**Consultation Response from KC,
Trees**

2026/90783 7, Wakefield Road, Grange Moor, Huddersfield, WF4 4DS

Erection of extension and refurbishments to former petrol filling station/car sales to form petrol filling station with retail, office, hot food take-away, car sales and repair facilities with canopy, car wash area, PF pumps, parking and storage tanks

Date Responded: 17/04/2026

Site Plan
1 : 200

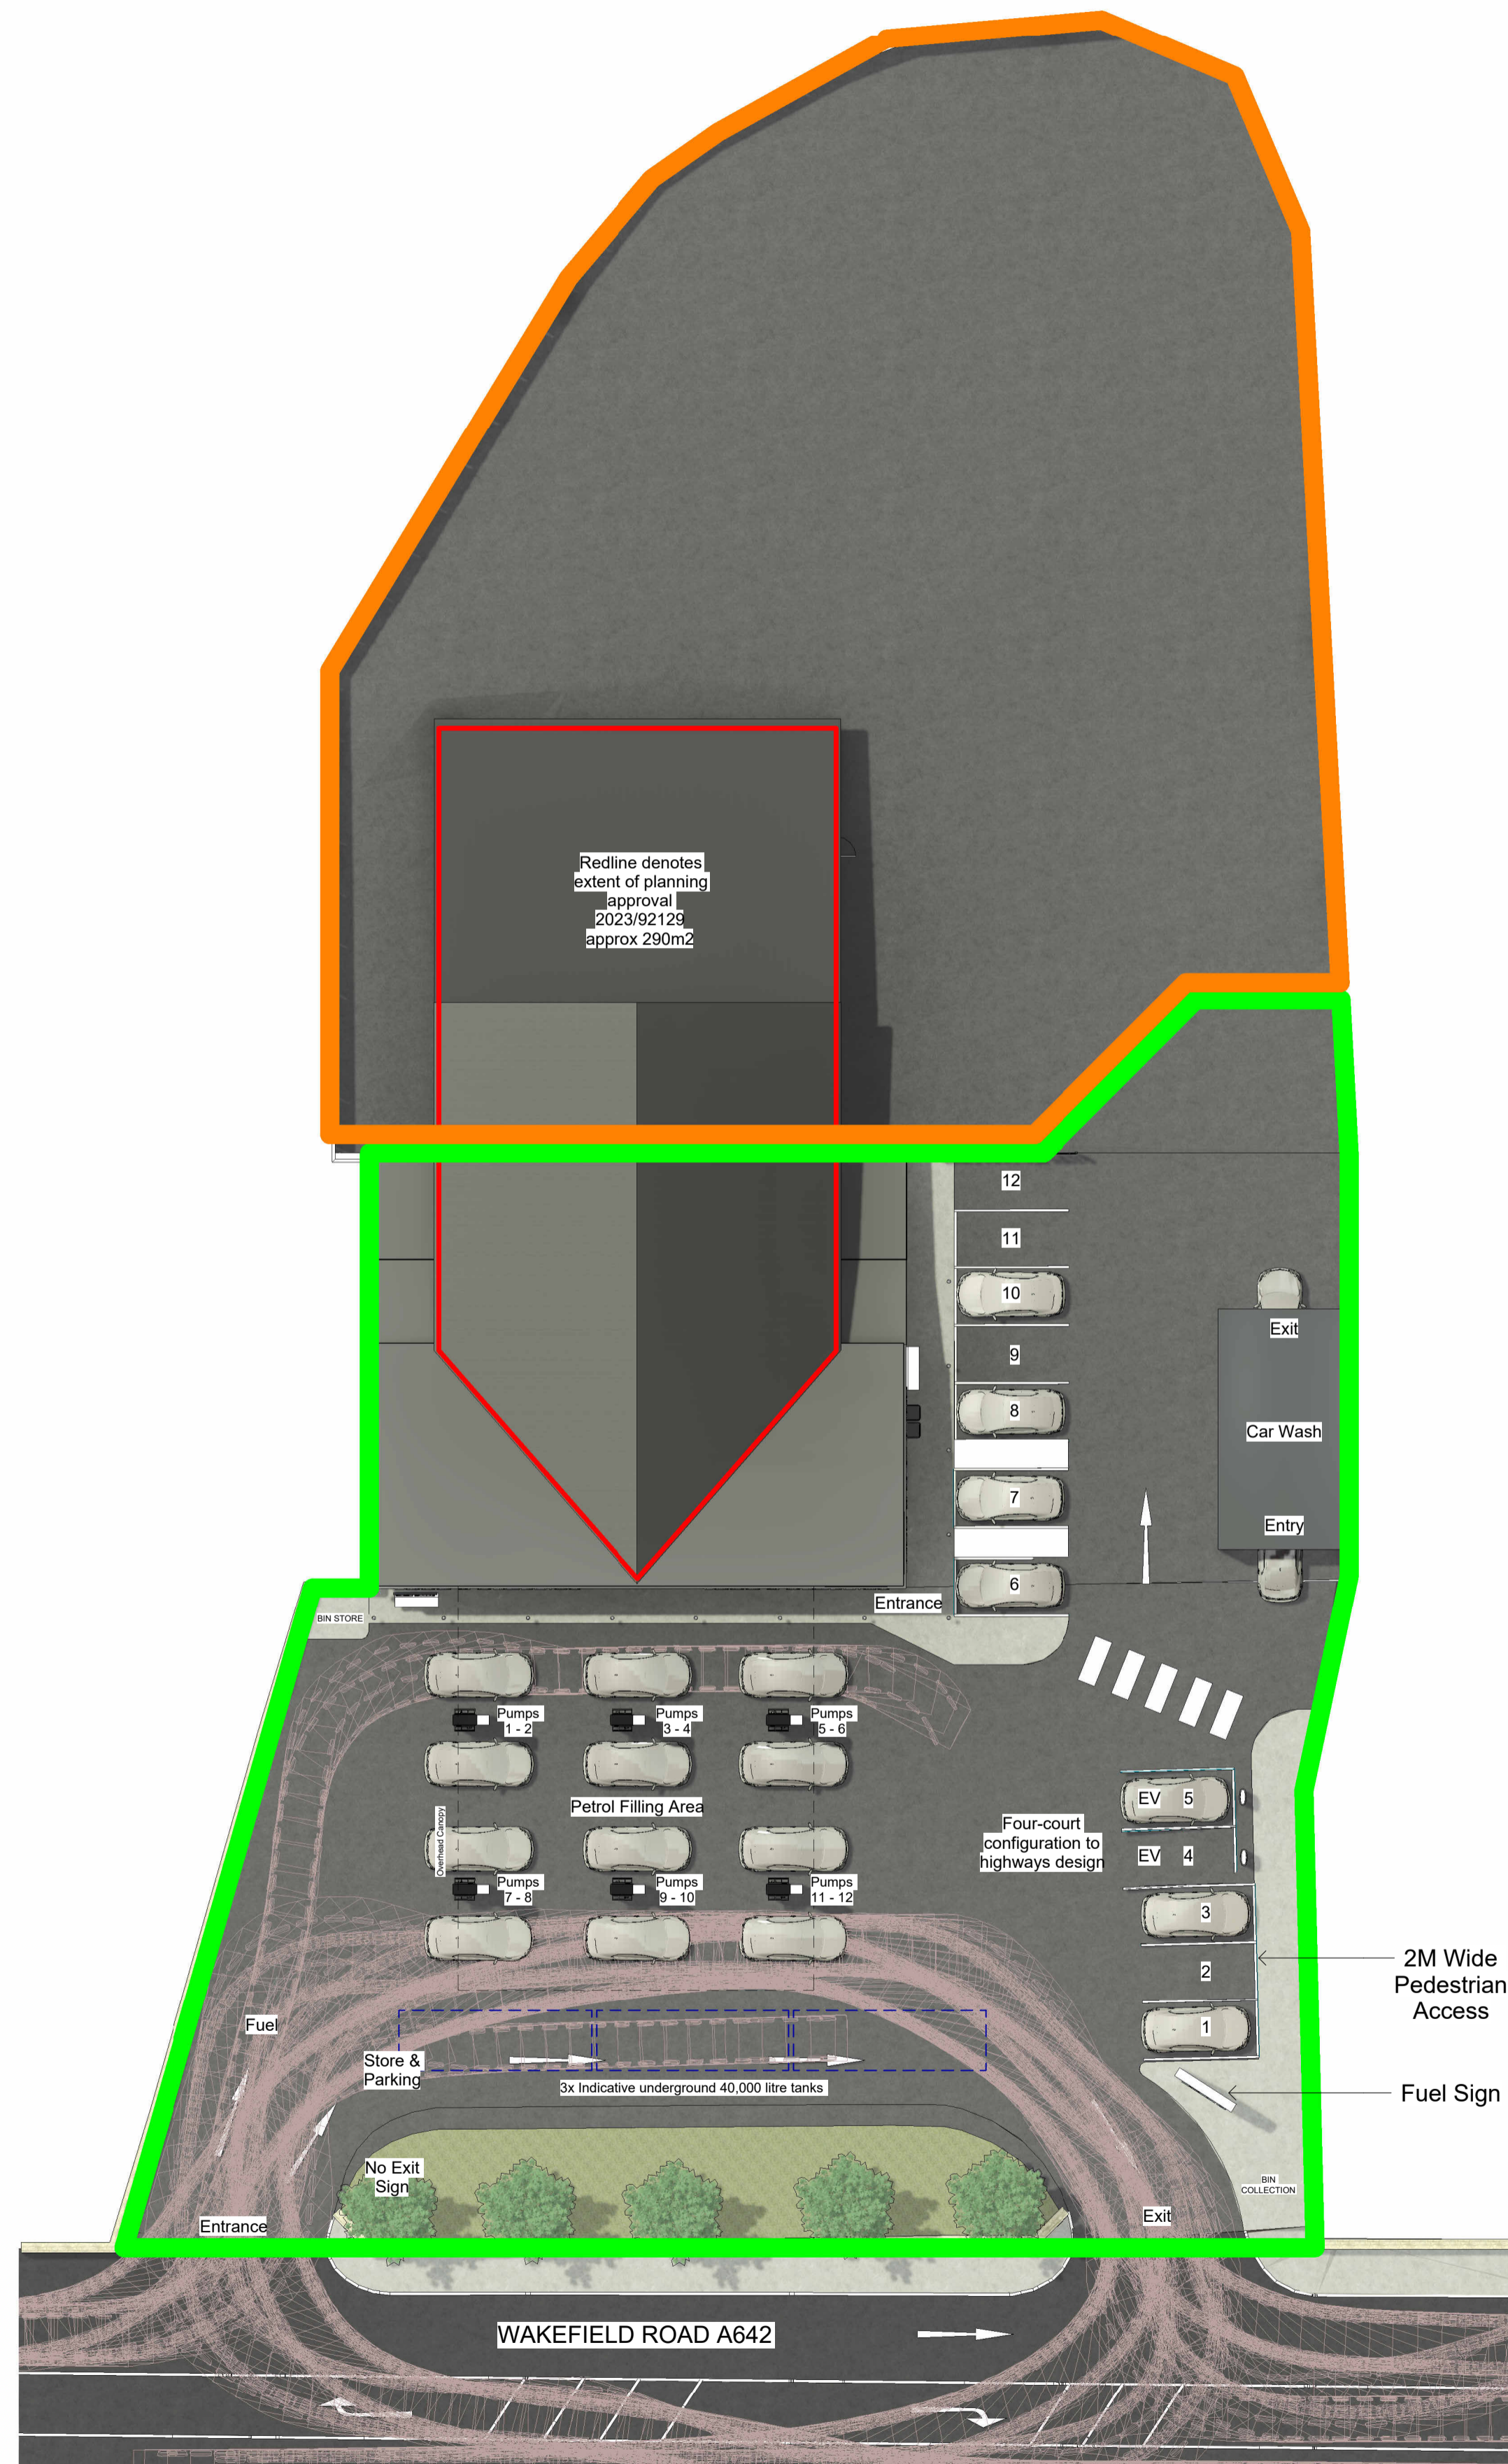
We require further information to understand whether any excavation would be required to lift the existing hardstanding within the RPAs, of trees and how the new surface and boundary treatments will be installed.

There is a holding objection from an arboricultural perspective. The proposal conflicts with adopted Kirklees local plan policy 33 and 24 (i):
